Application by Vattenfall Wind Power Limited for the Thanet Extension Offshore Wind Farm Development Consent Order

The Examining Authority's second written questions and requests for information (ExQ2)

Issued on 10 April 2019

Land Plan (Onshore)

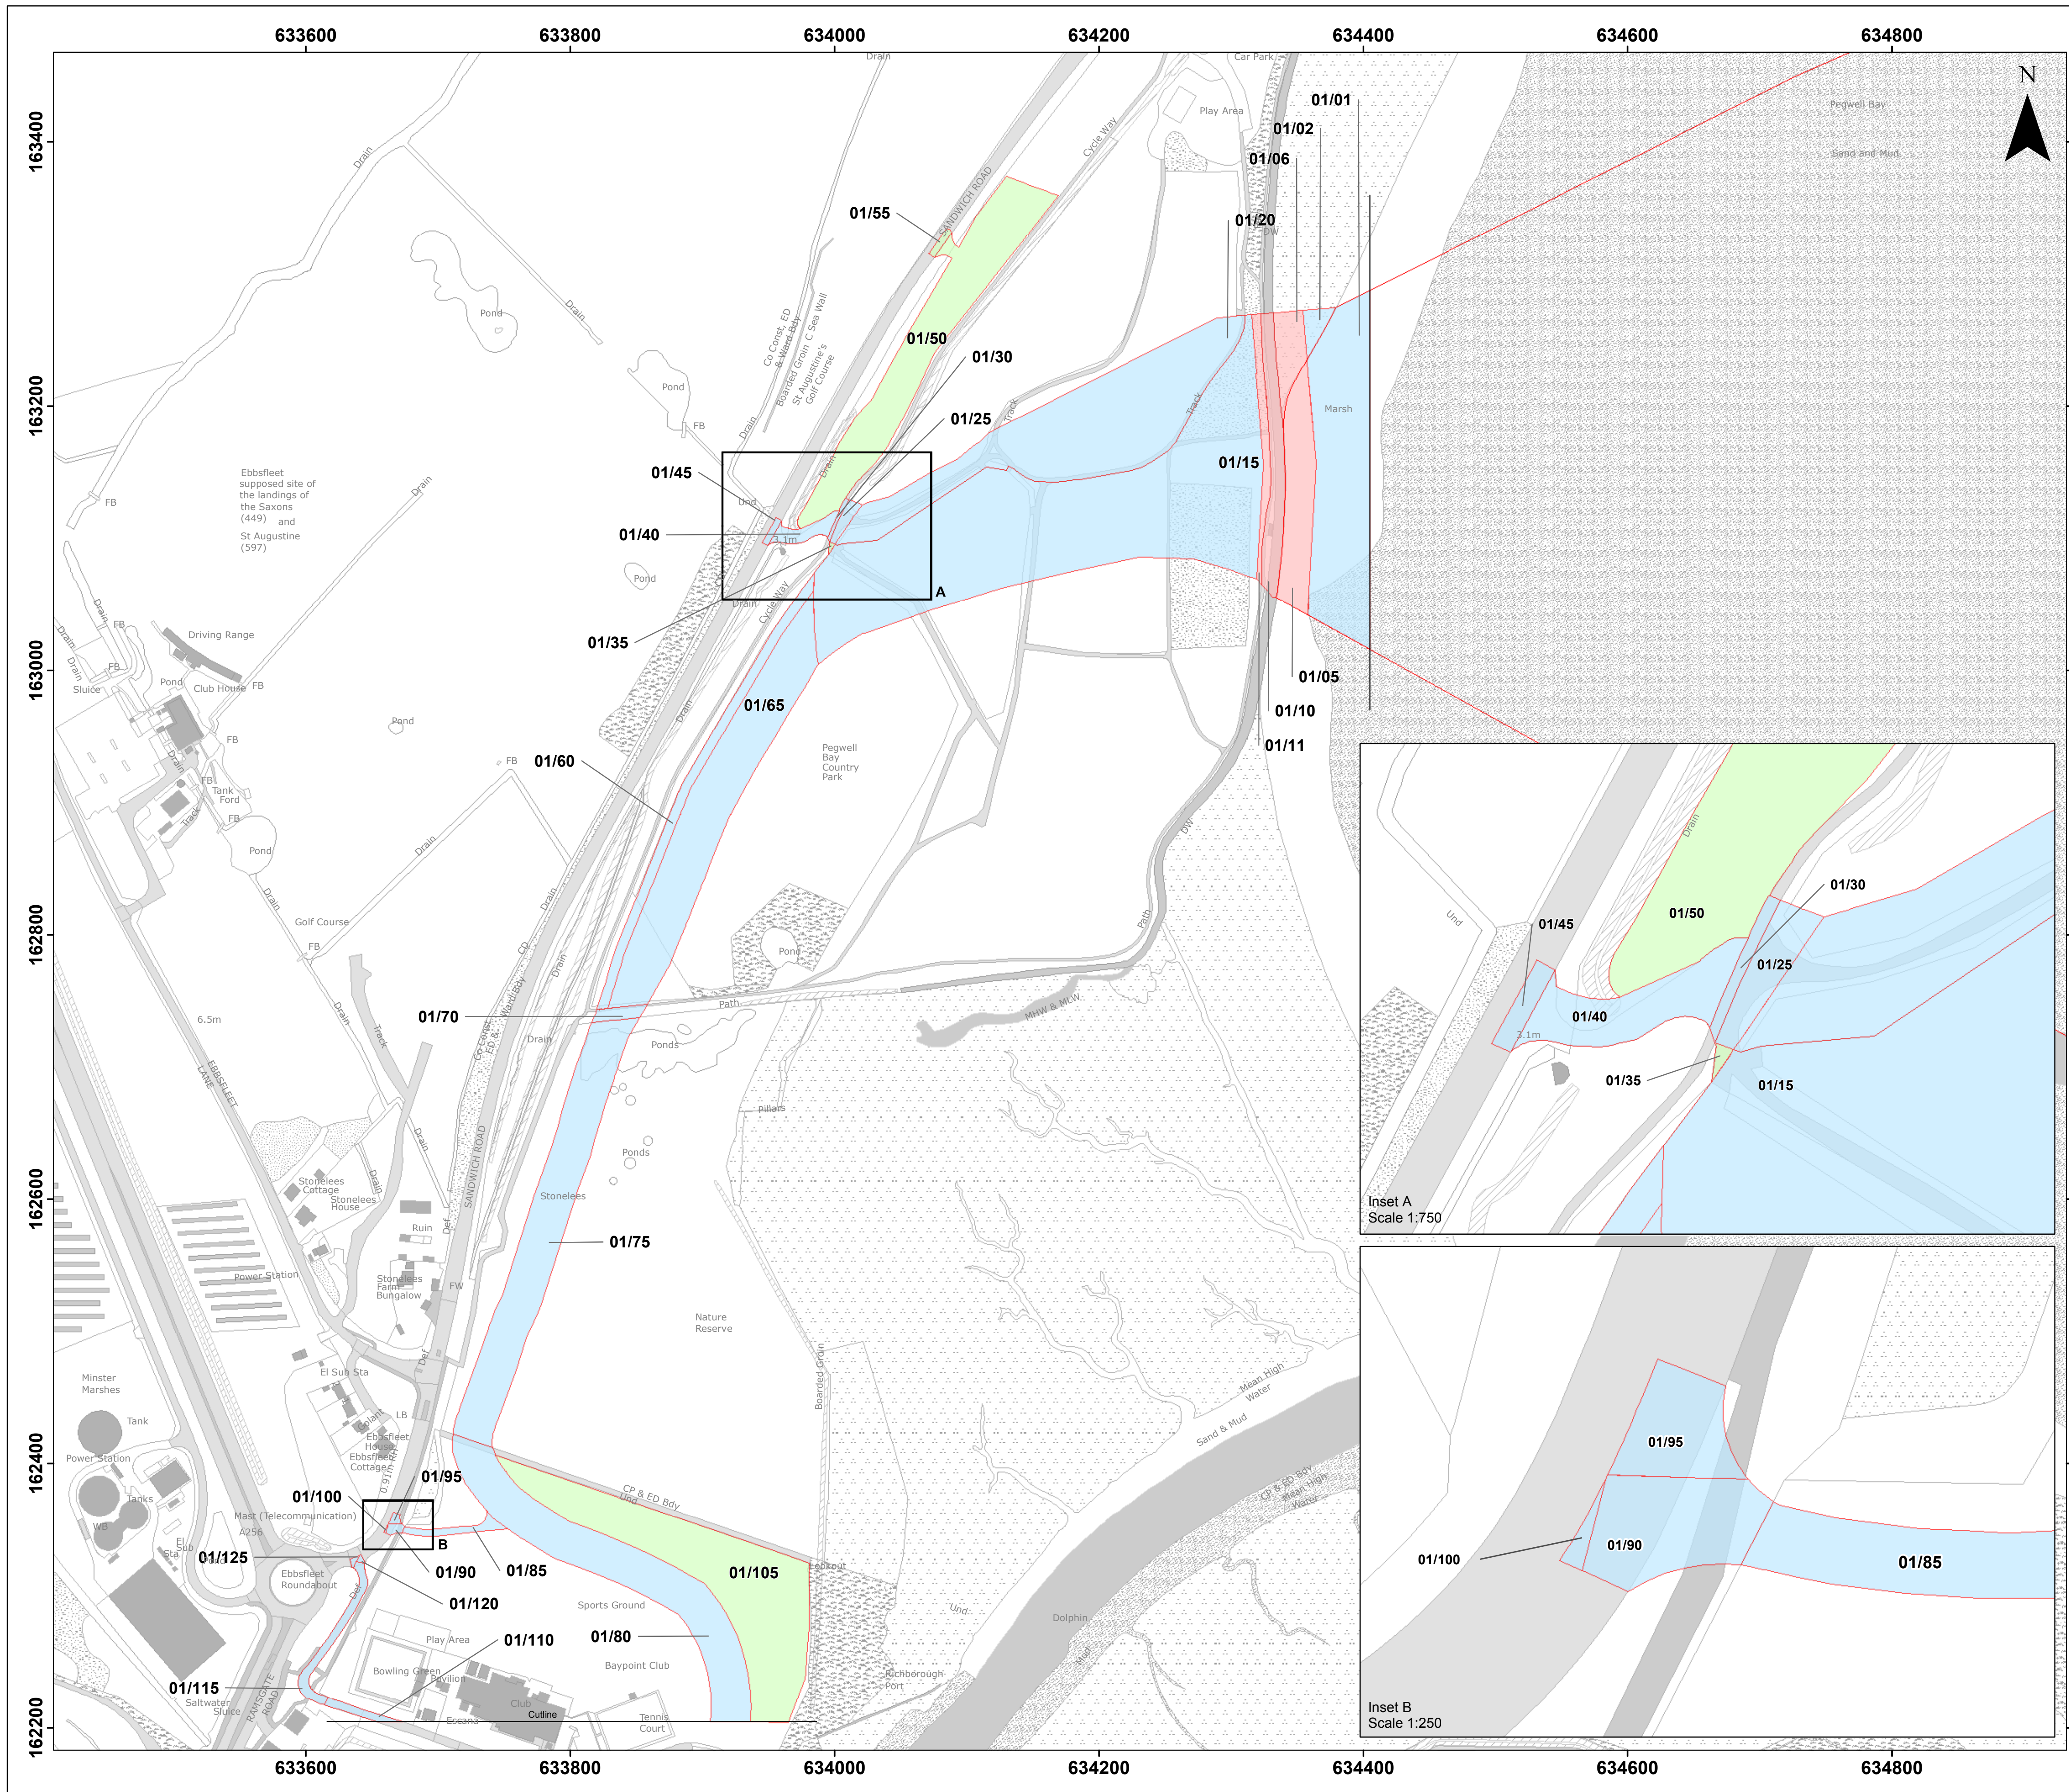
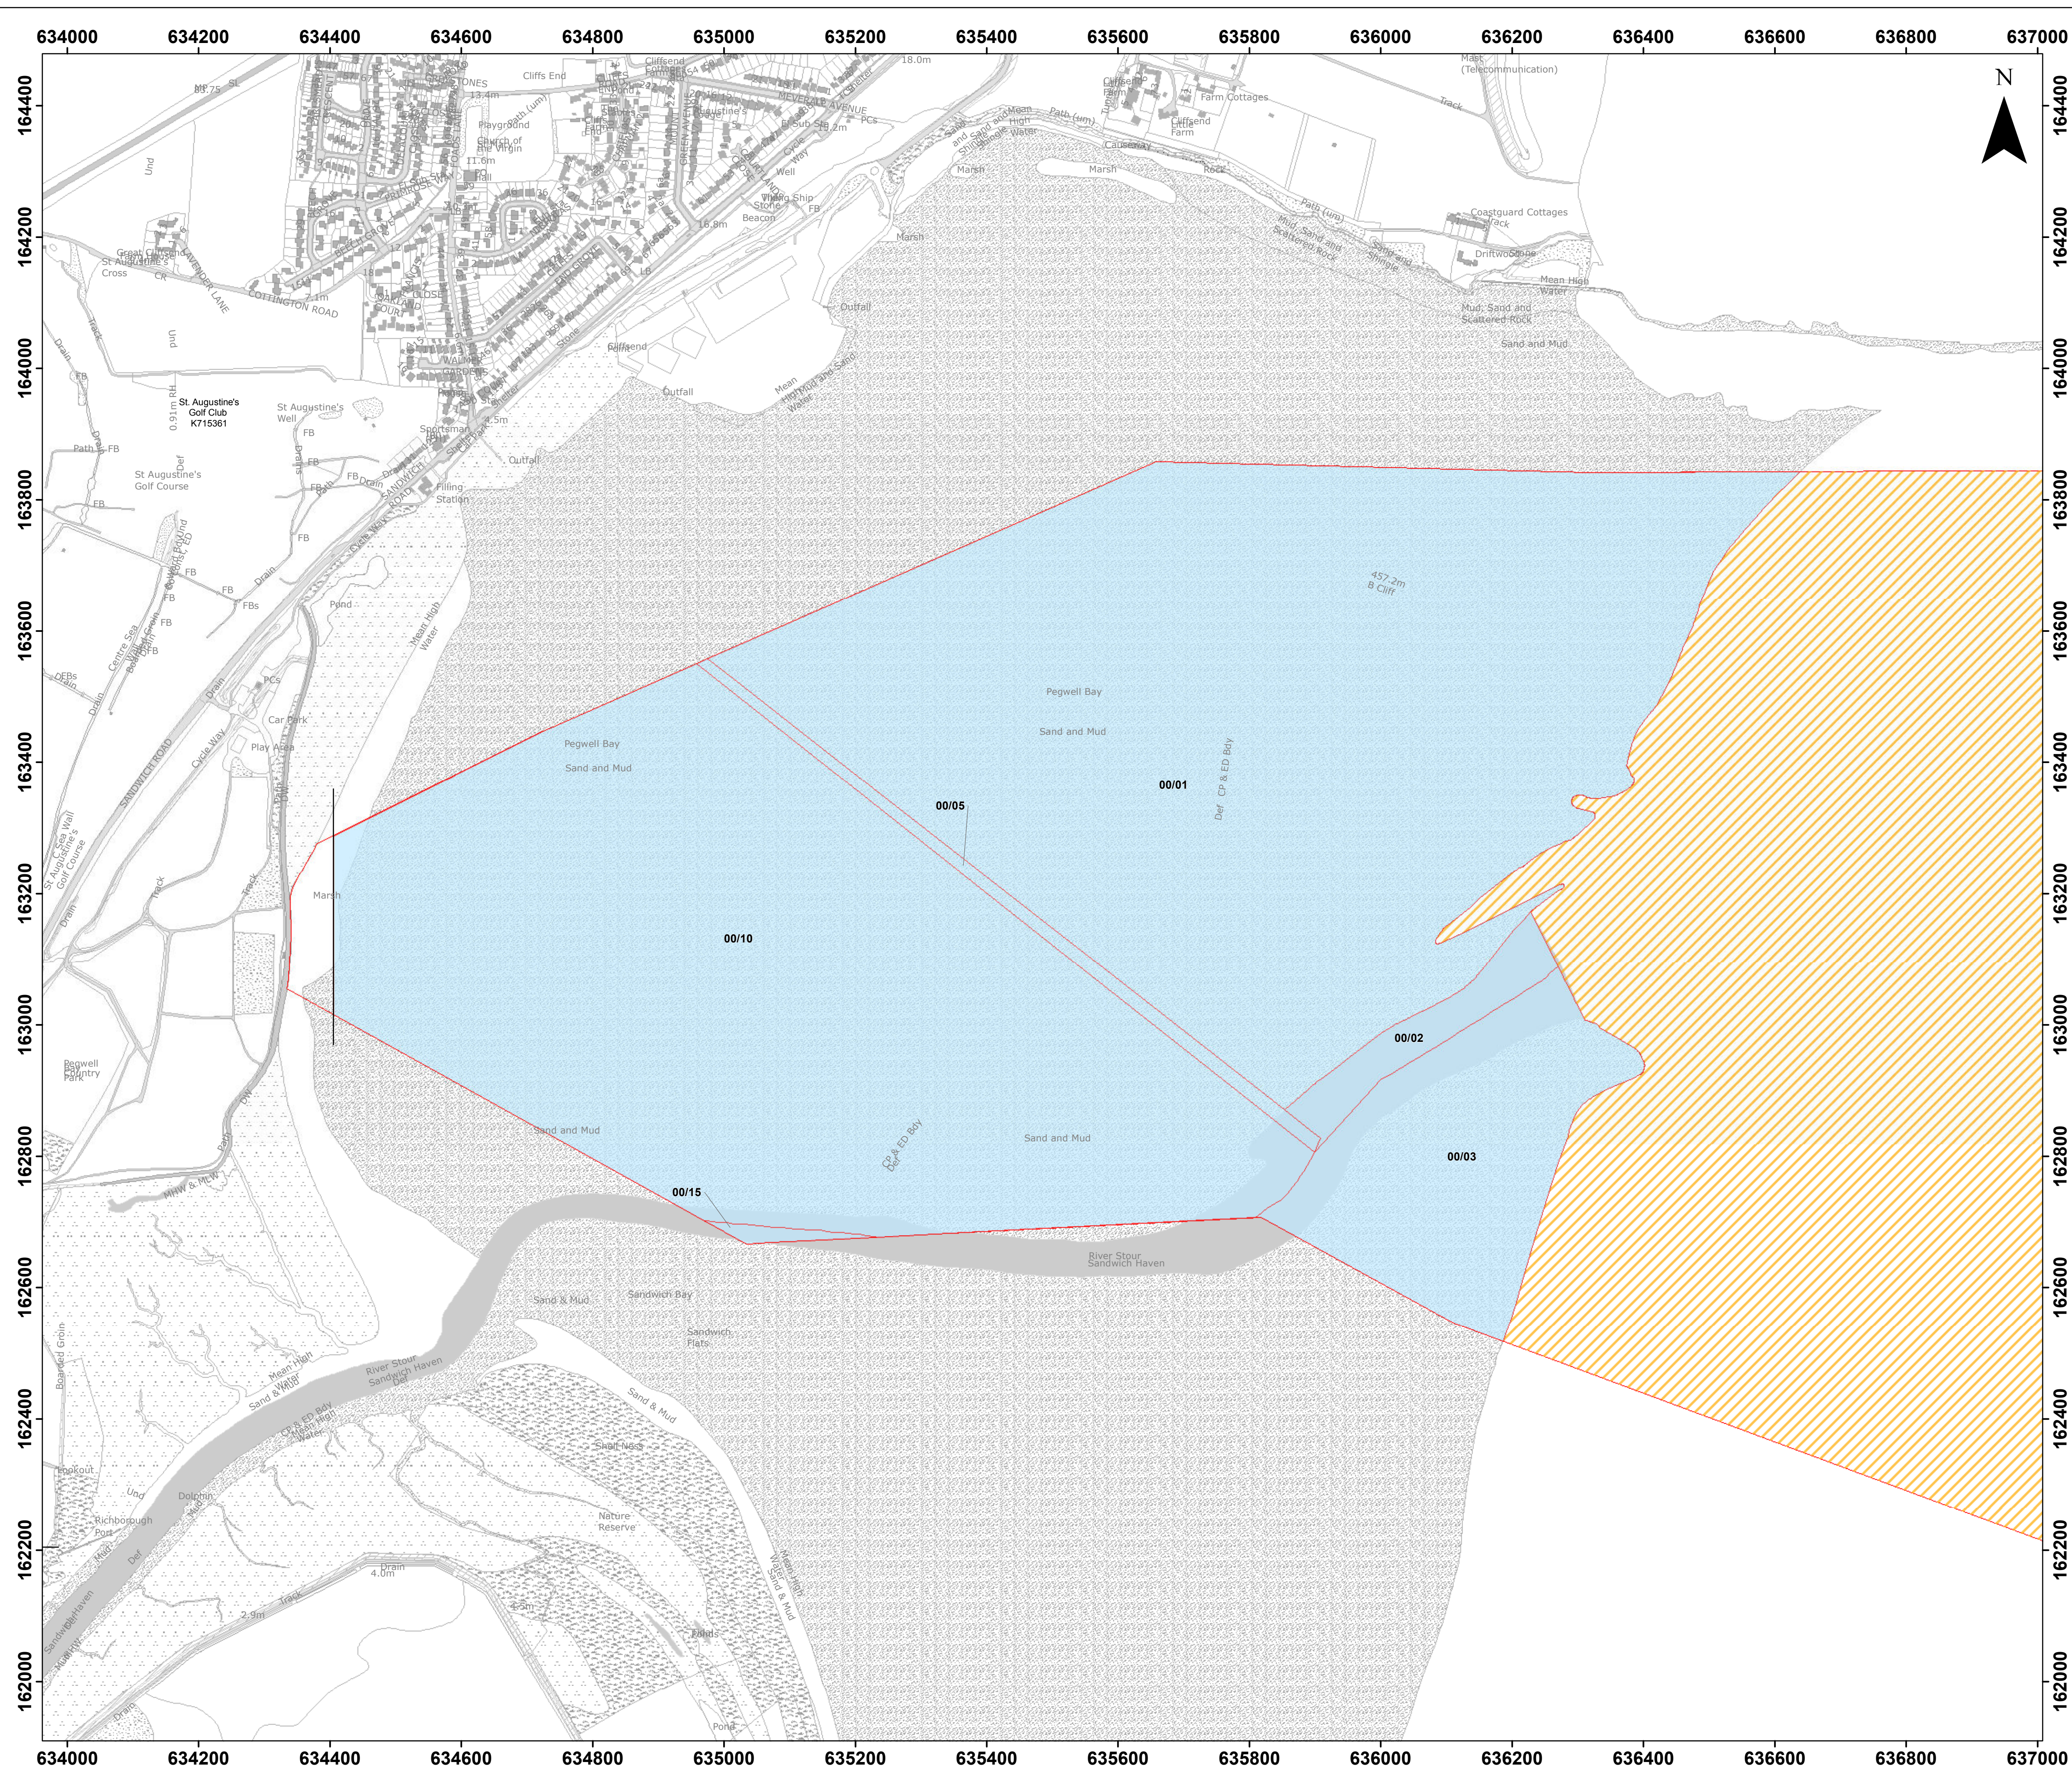
2.1.5.	The Applicant and Ramac	<p>Excluded Land: Parcel 02/75 The Onshore Land Plans identify a small plot of land excluded from the CA request for permanent freehold acquisition on Parcel 02/75.</p> <ul style="list-style-type: none"> a) Can the Applicant please explain the purpose for which this land has been excluded. If the exclusion is in error can the Onshore Land Plans be replaced at Deadline 5. b) Can Ramac please review the Applicant's response to this question at Deadline 5 and if the exclusion is intentional, please identify what effect the exclusion of this land from CA will have on Ramac <p>{See Land Plans extract identifying the plot}</p>
